Our Ref: BR/10/21/DOC

Approval of details reserved by condition imposed under ref BR/257/17/PL relating to Condition Nos 3 - materials & finishes, 6 - cycle parking and 8 - recycling & refuse enclosure.

12 Tennyson Road Bognor Regis PO21 2SB

PROPOSED SITE PLAN
(NO CHANGE)

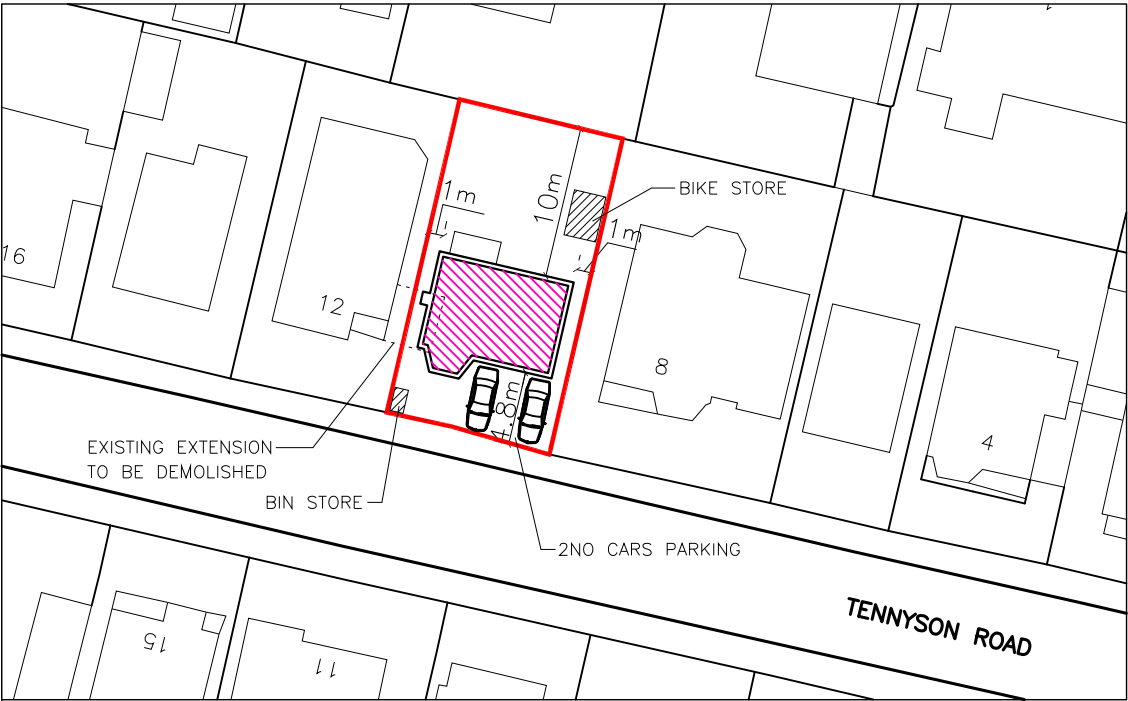
The applicant has demonstrated the location of secure and covered cycle parking provision on the submitted site plan Dwg No 101 Rev A and a photo of shed. The LHA is satisfied that Condition 6 can be discharged.

The condition is therefore fully discharged insofar as the submission of site plan relates and on the understanding that the cycle storage shed will be permanently retained.
